Our Ref: BR/98/17/PL
Your Ref:

Town & Country Planning Act 1990 (as amended)
Town and Country Planning (Development Management Procedure) (England) Order 2015
Application for Planning Permission

Development Conversion of part existing building to 'Fish & Chips' shop including new timber storefront with glazing, M&E extraction to shop front, timber stall riser, awnings, bi-folding doors, double door to entrance & new timber fascia.

Location Butlins South Coast World Upper Bognor Road Bognor Regis

FRONT 01 ELEVATION

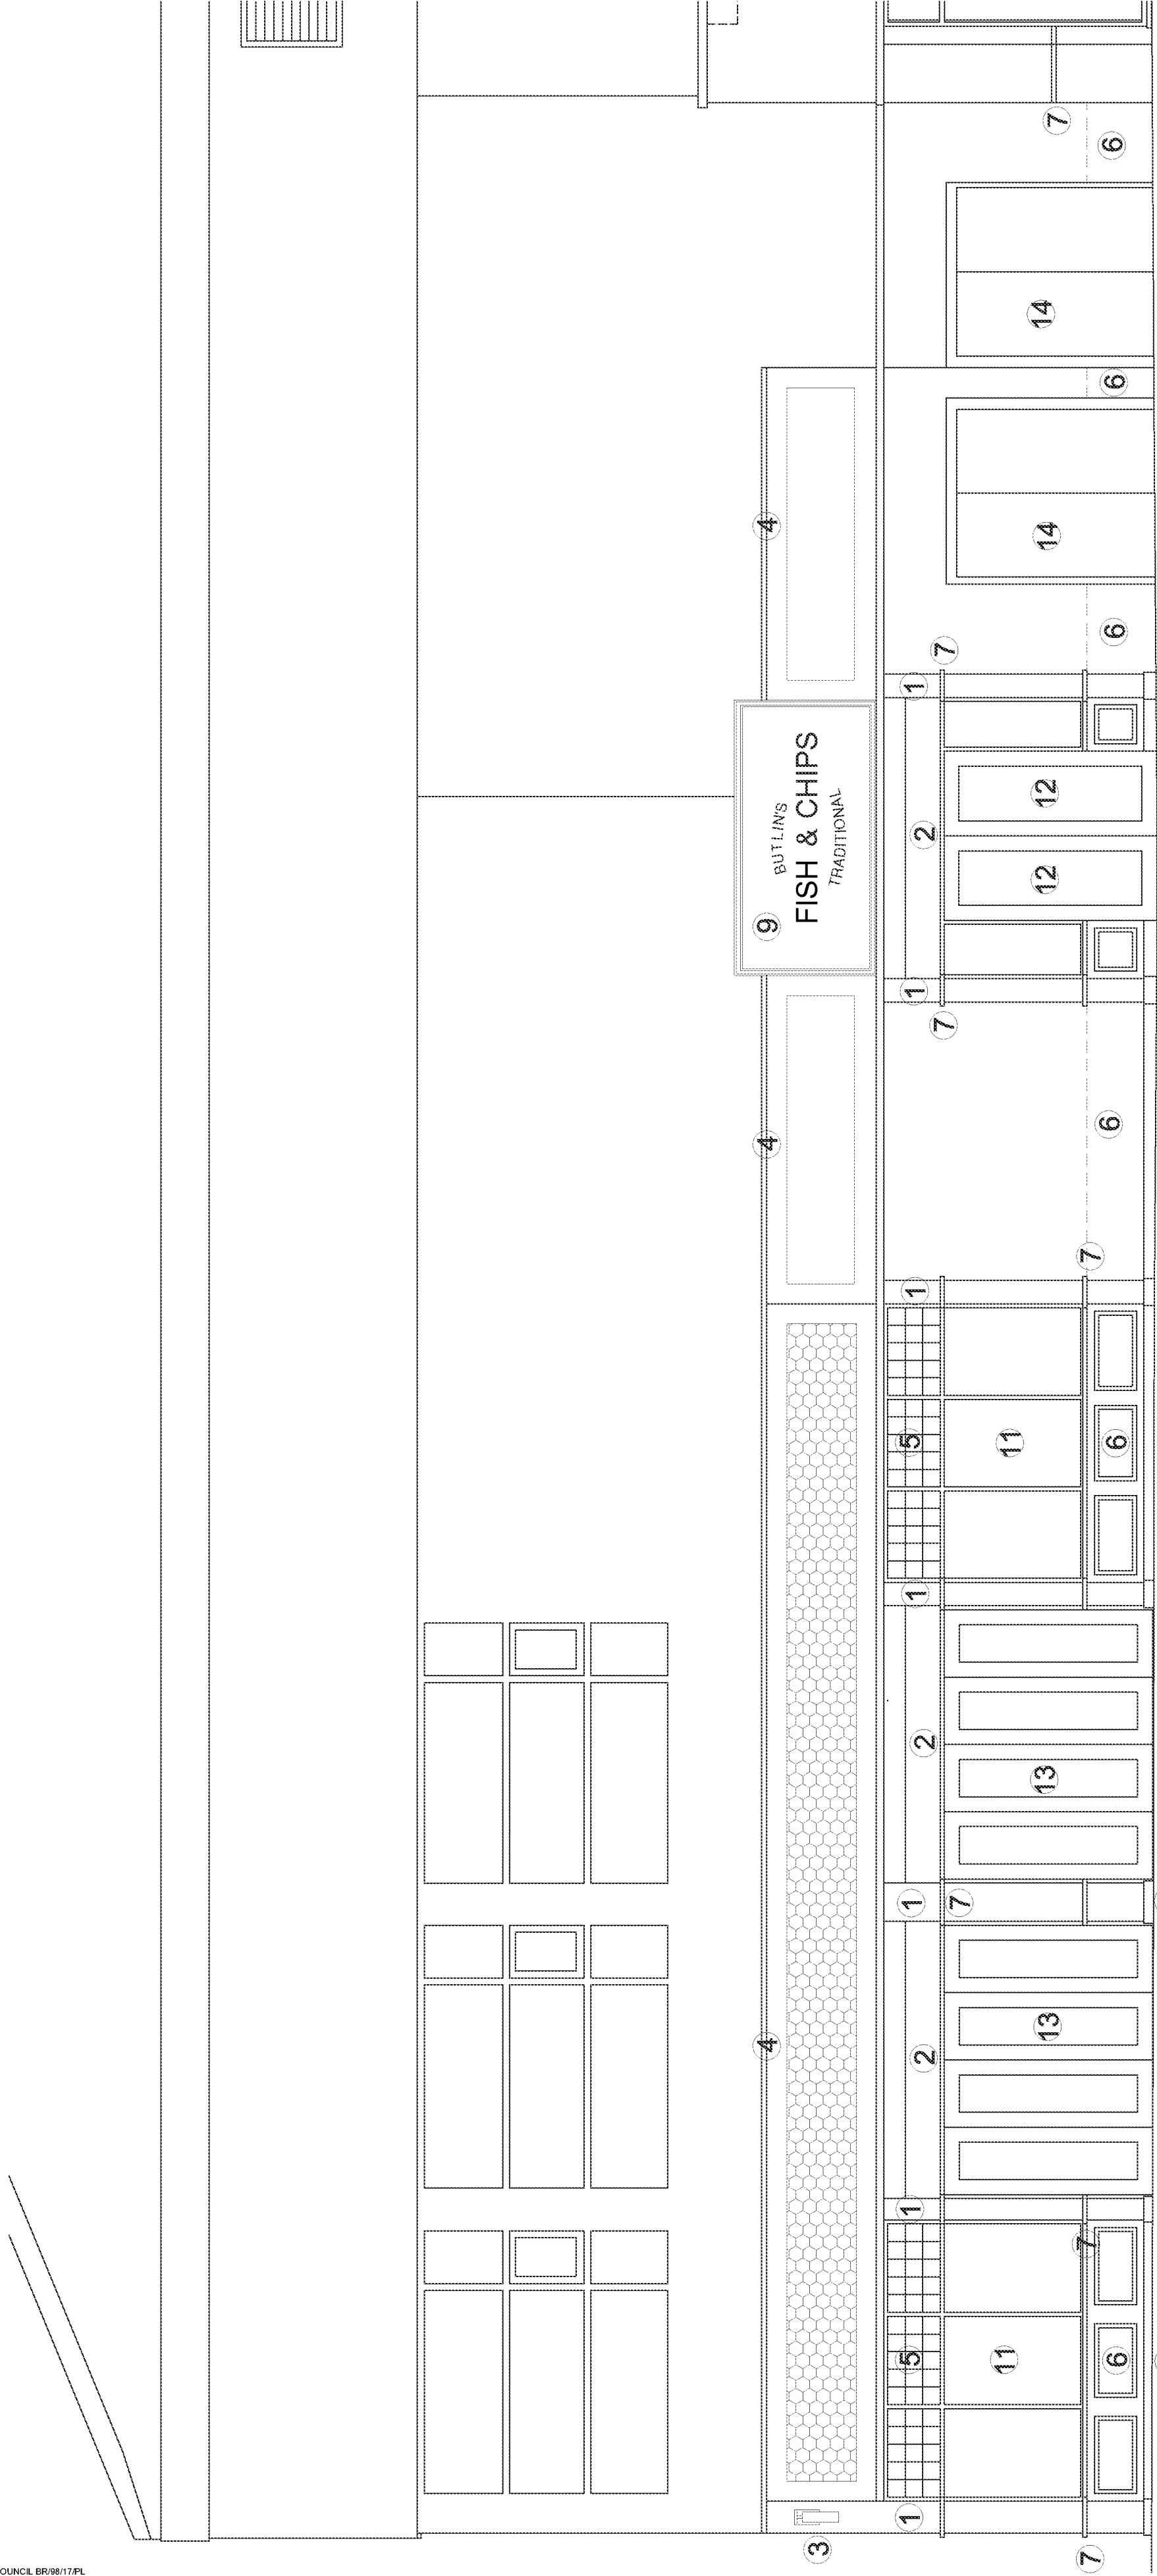
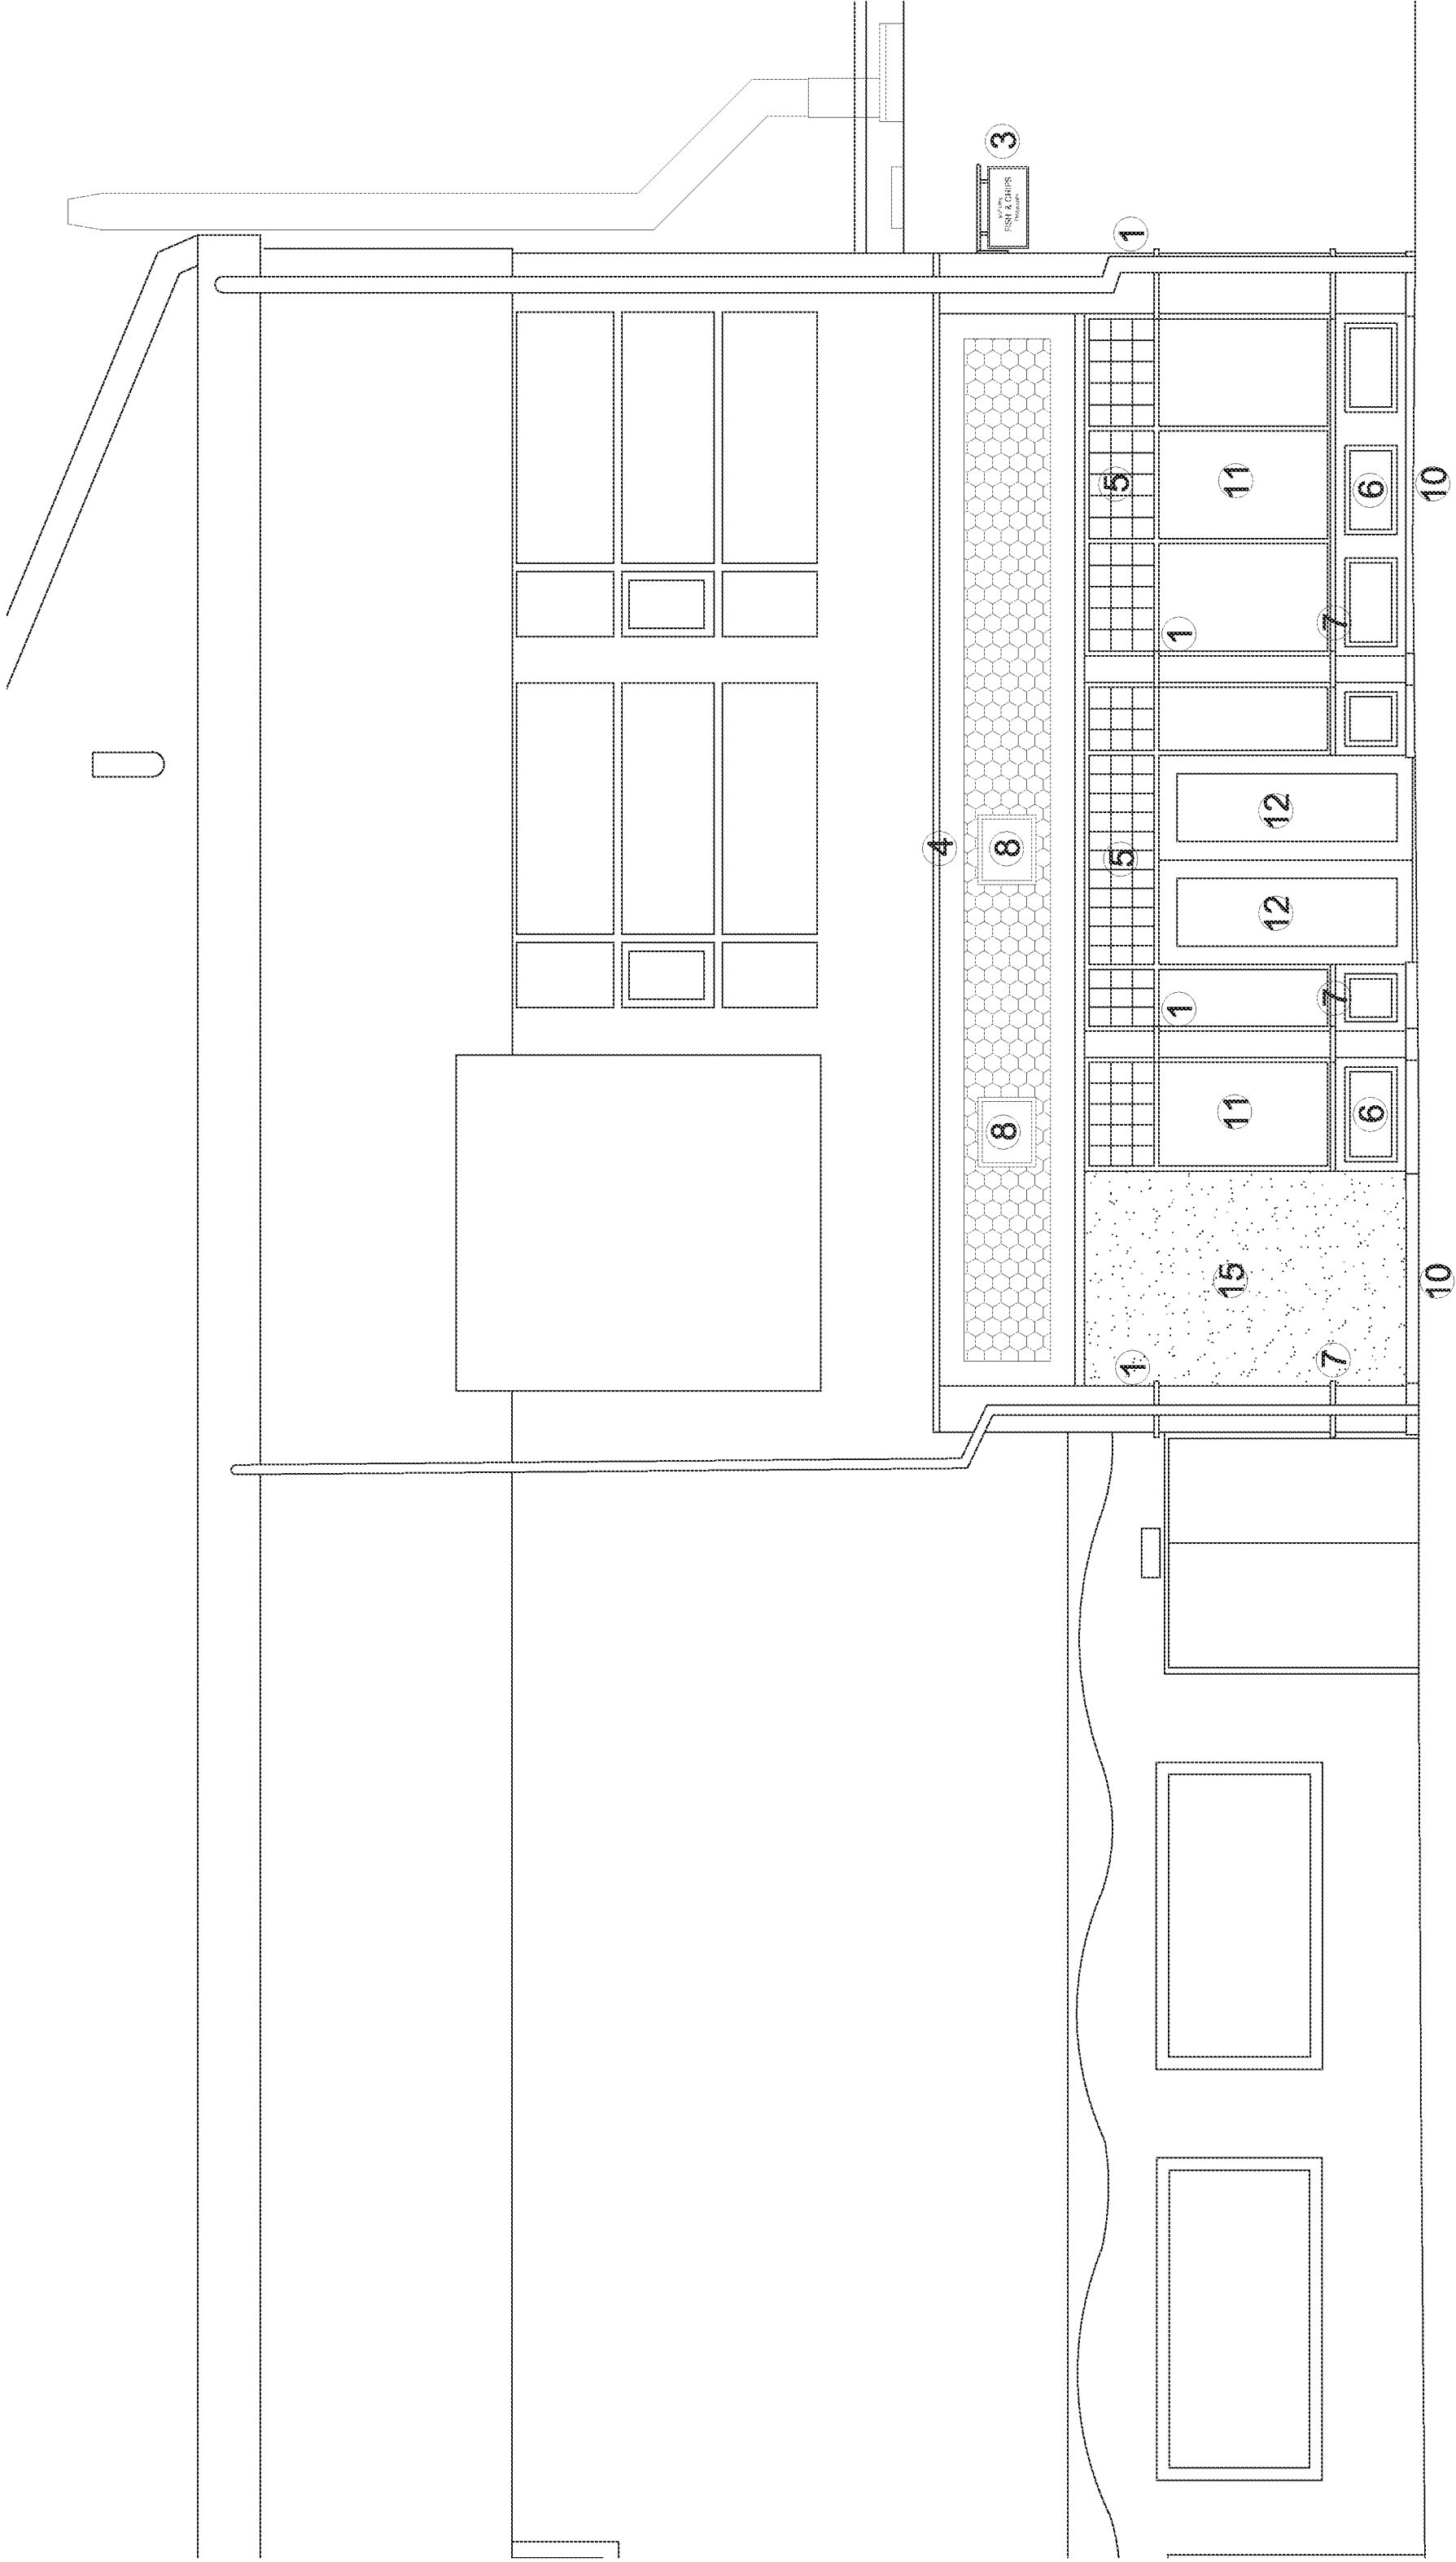
The proposed front elevation (01) and proposed floor plans do not accord. Please amend accordingly.

Proposed Plans

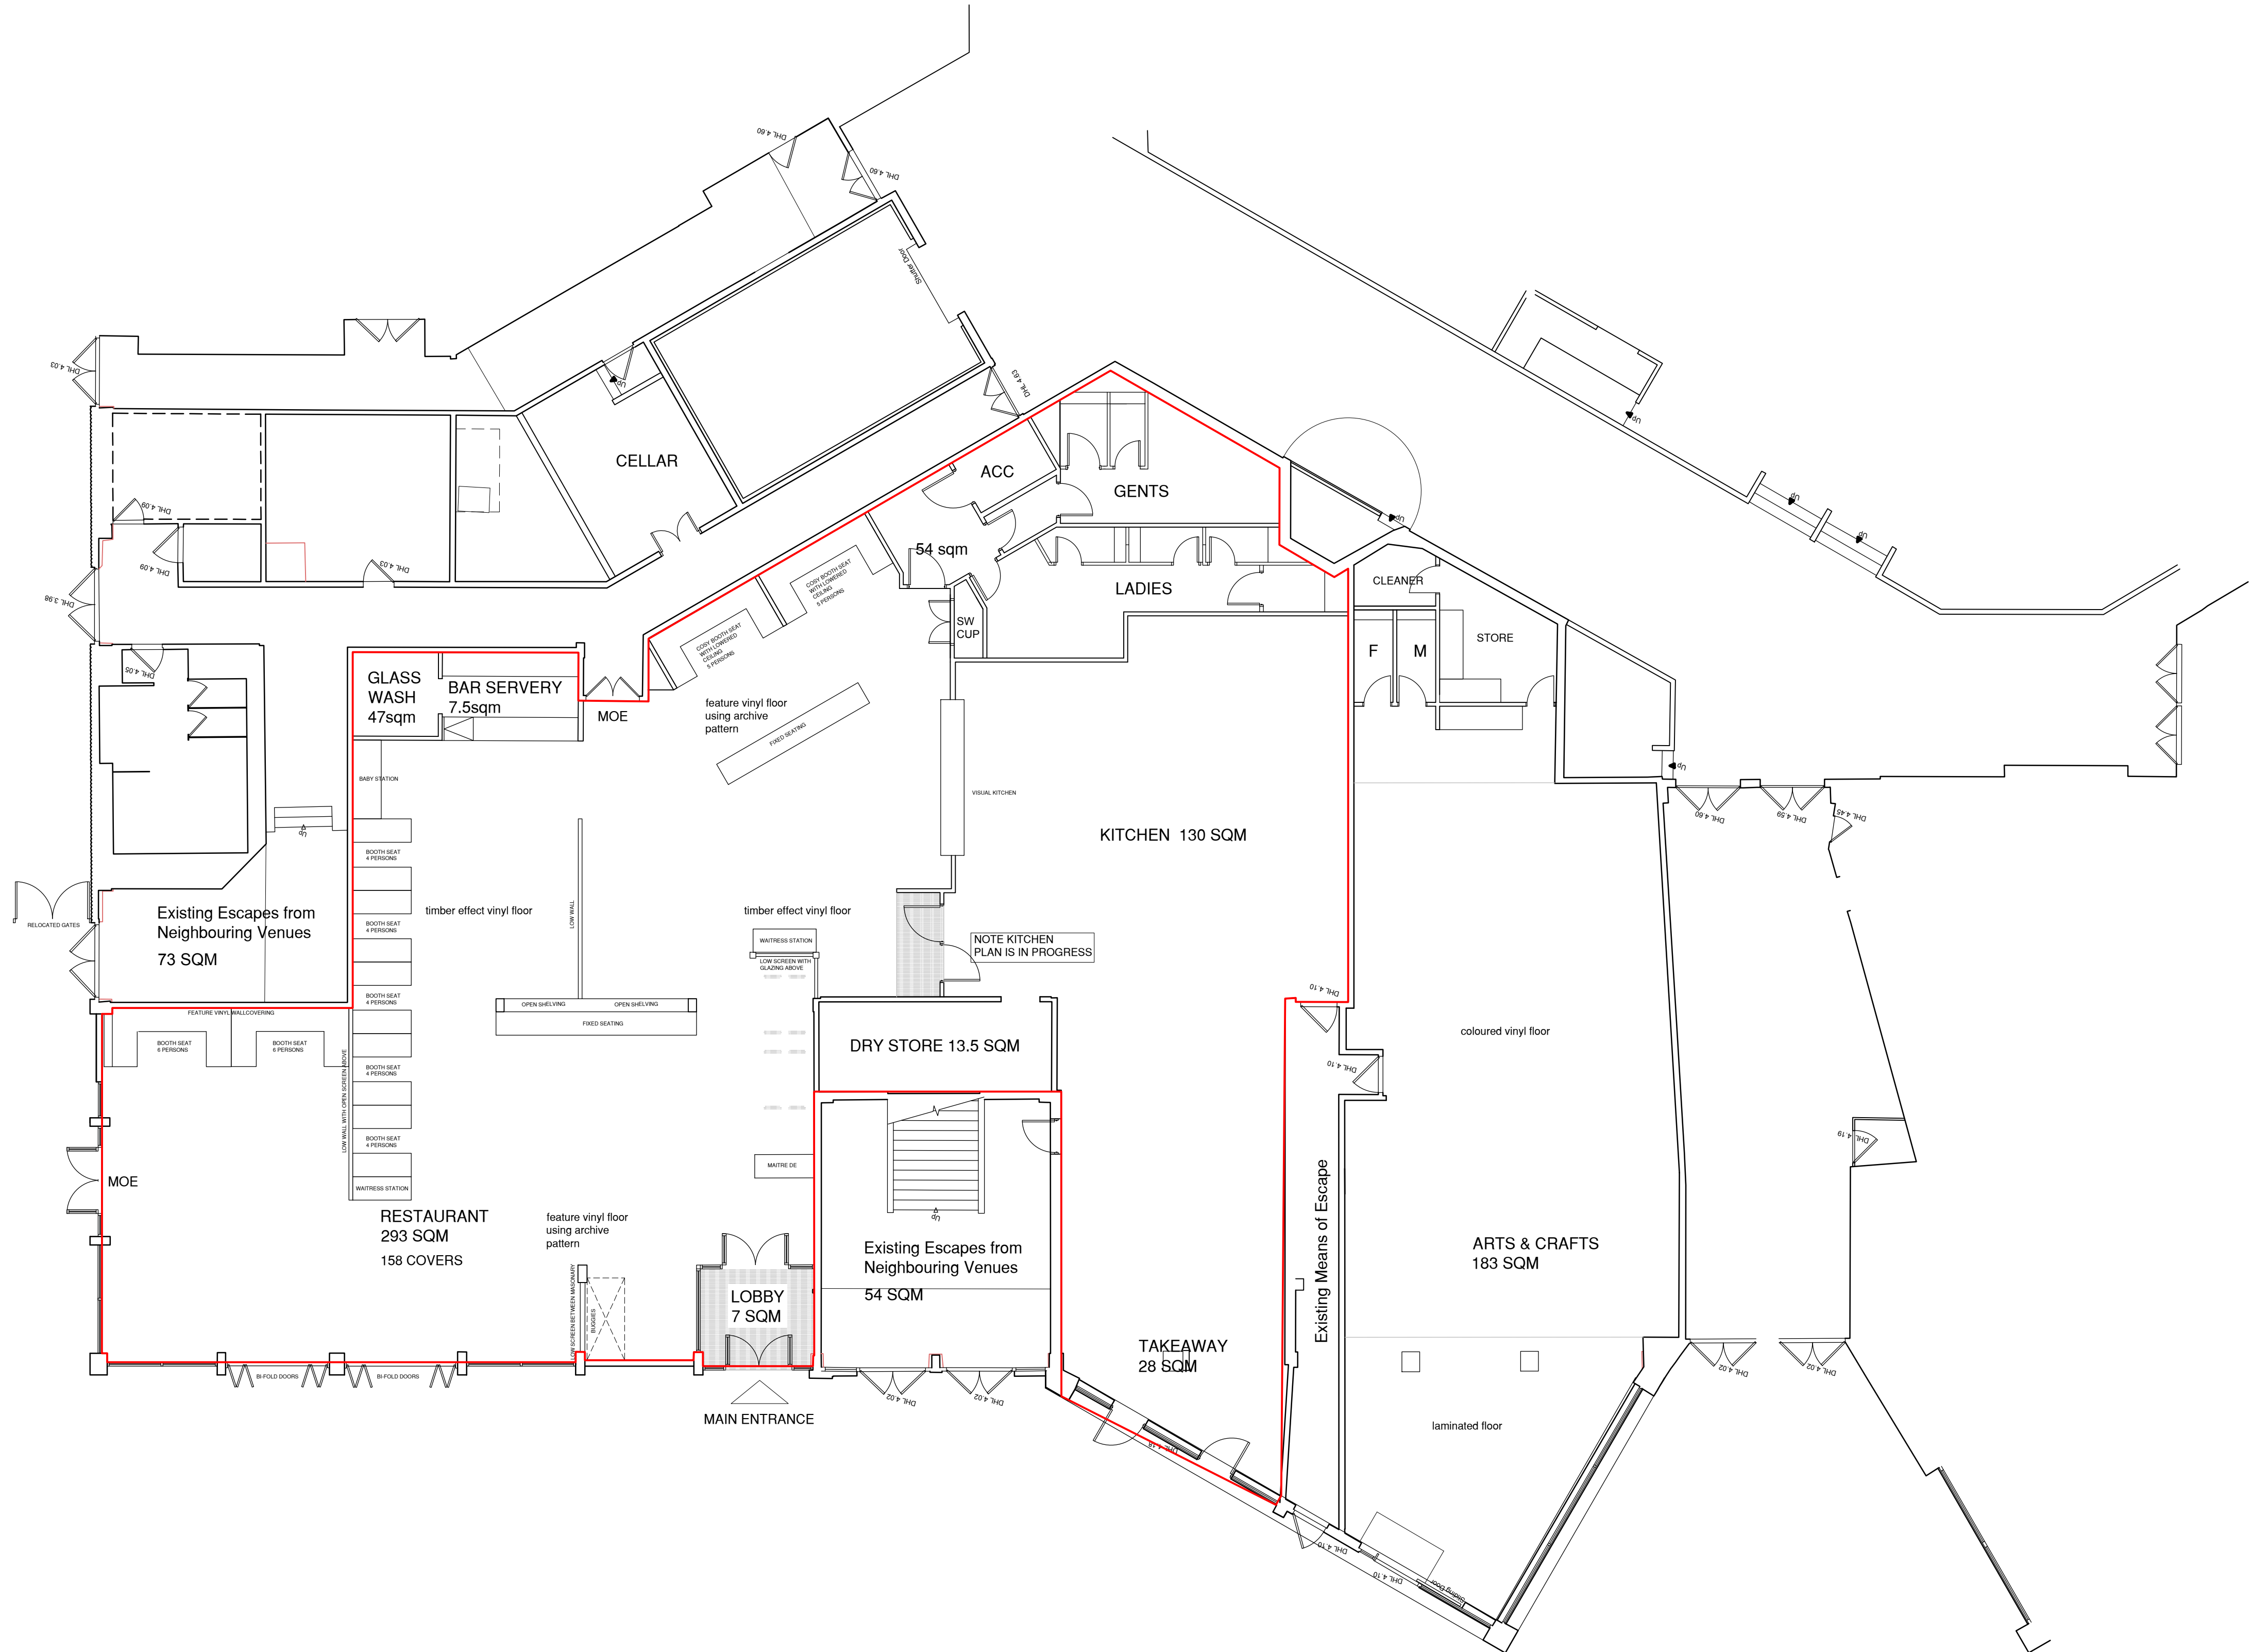
Please red edge the application site on the proposed floor plan to match the red edge on the existing floor plan.

The proposed rear elevation and proposed floor plan do not accord. Please amend accordingly.
